**We strongly object to this development on the following grounds.**

**[REDACTED]**  
**Prospect House**  
**Fringford Road**  
**Caversfield**  
**Bicester**  
**Oxfordshire**  
**OX27 8TH**

Drawing Title:
**Proposed Floor Plans &
Elevations
PLOT 4 & GARAGE**

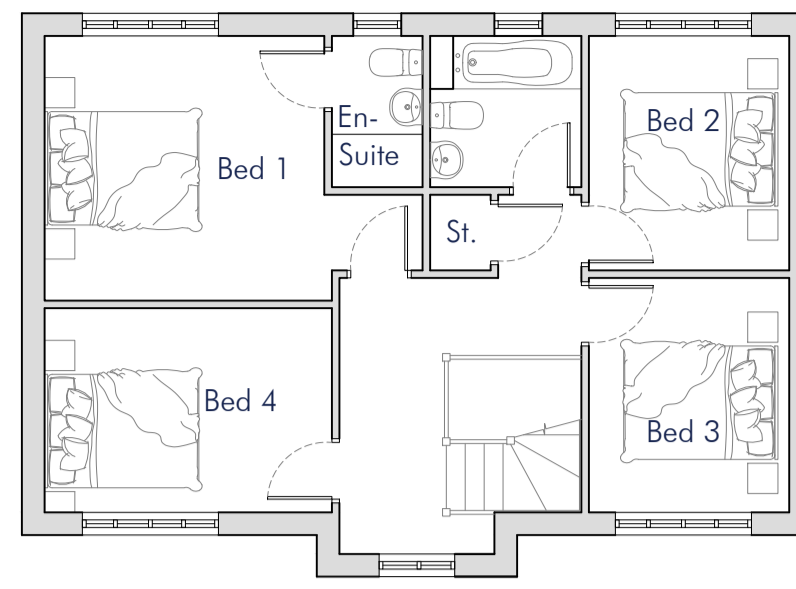
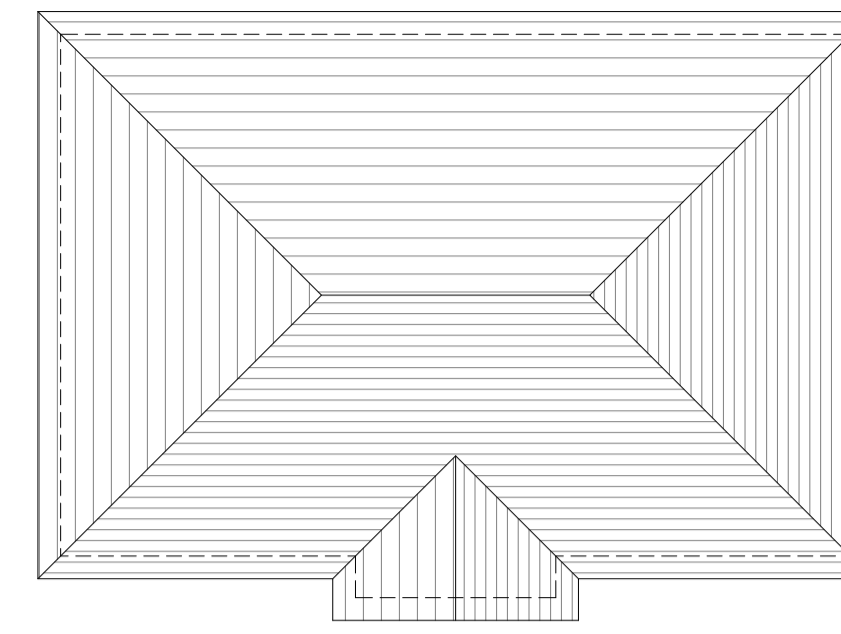
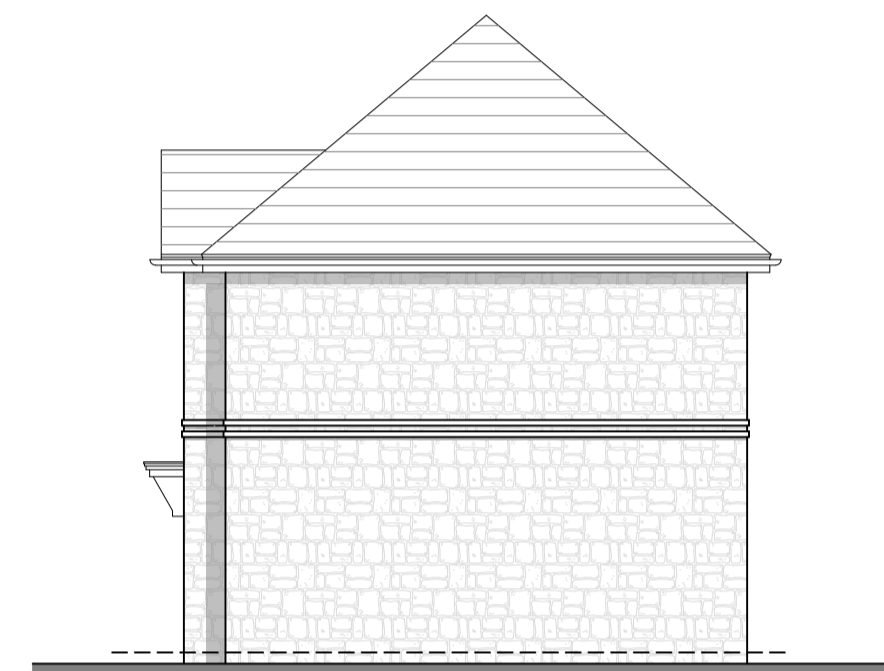
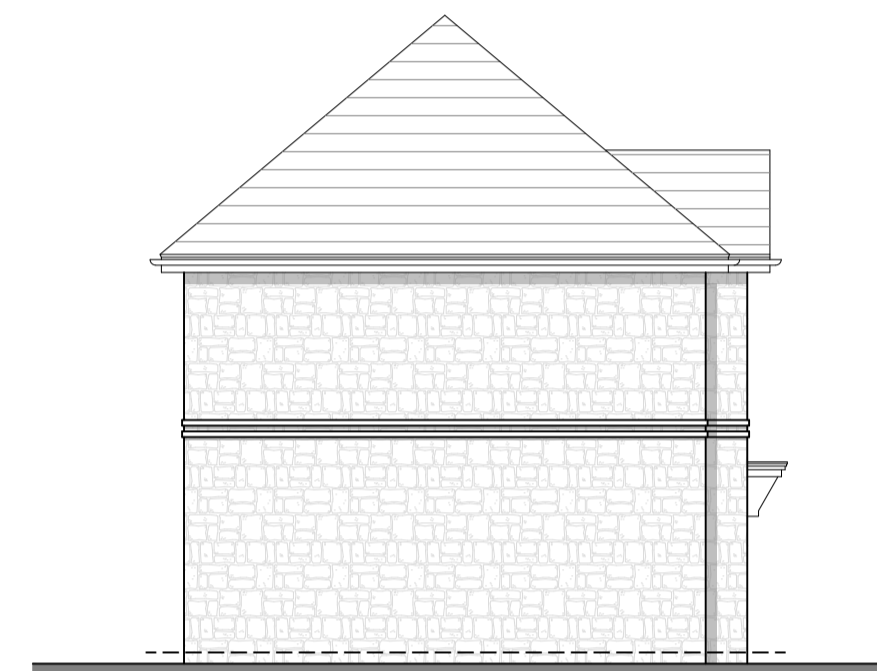
**c.** The 4 bedroom detached house with garage is too close to the boundary with Prospect House – less than 2 meters. This will cut off light to the garden.

**The build on plot numbered 4 is too close to the boundary of the neighbouring property (Prospect House).**

Drawing Title:
Proposed Site Plan & Layout

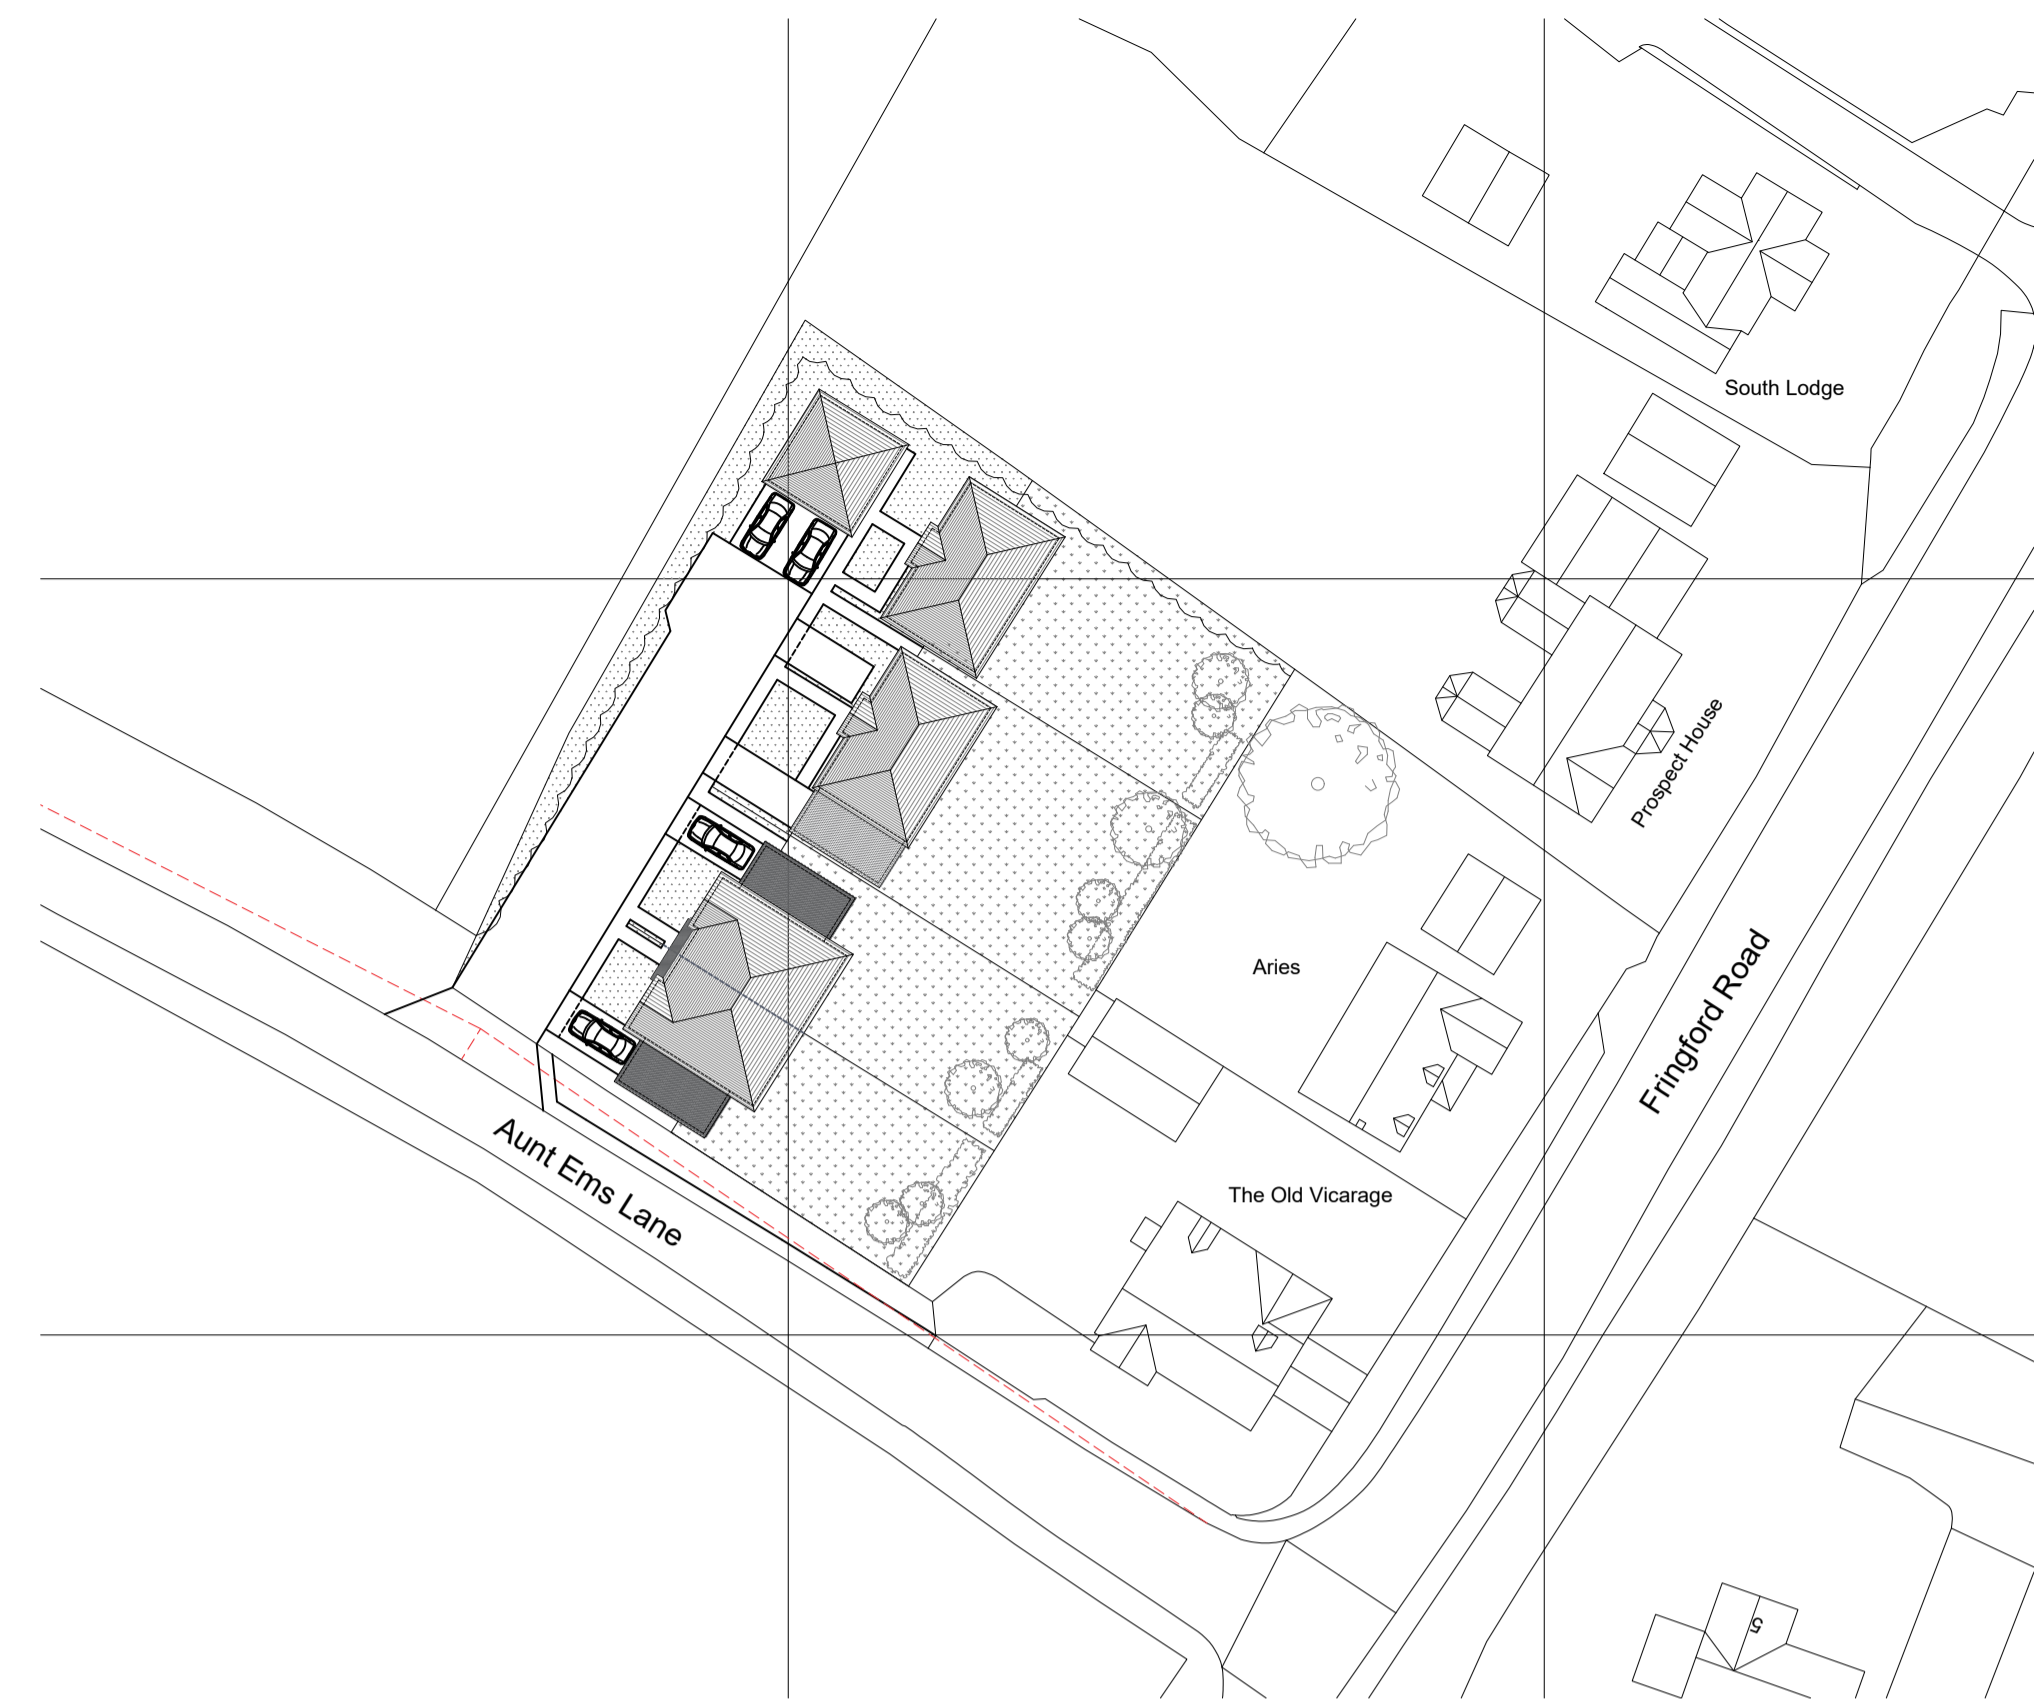
**4)a.** The access to the site is on the very narrow Aunt Ems Lane. Most of this lane has a speed limit of 60mph. The limit changes to 40mph heading towards the Fringford Road at the very point of the intended access to this site of 4 houses and in the other direction changes from 40mph to 60mph, again at the very point of the intended access.

**b.** The access is very close to the substandard junction with Fringford Road which has a 40mph speed limit and no lighting. Cars are prone to drive much faster than the limit. Turning right onto Fringford Road is a blind spot. There have been a number of accidents at this junction.

**c.** The width of the proposed drive/road leaves very little room to turn a full 180 degrees therefore I envisage cars reversing out of the drive/road onto a very busy lane which is extremely close to a very busy junction. This has been made even busier at peak times due to the difficulty turning right from Fringford Road onto Southwold Lane, because of the junction's proximity to the roundabout.

**d.** The exit from the proposed site will be severely disadvantaged by the existing hedgerow to the right. As this does not belong to the residents they will be unable to modify the hedgerow. This is also at the very point where the speed limit changes from 60mph to 40mph.

**e.** Parking will also be a problem with visitor and deliveries parking on the narrow Aunt Ems lane or around the corner on the busy Fringford Road.

**b.** The preserved hedgerow in front of the build will be right next to the driveway/road catering for 11 cars. This will surely have an impact on the wildlife living there.
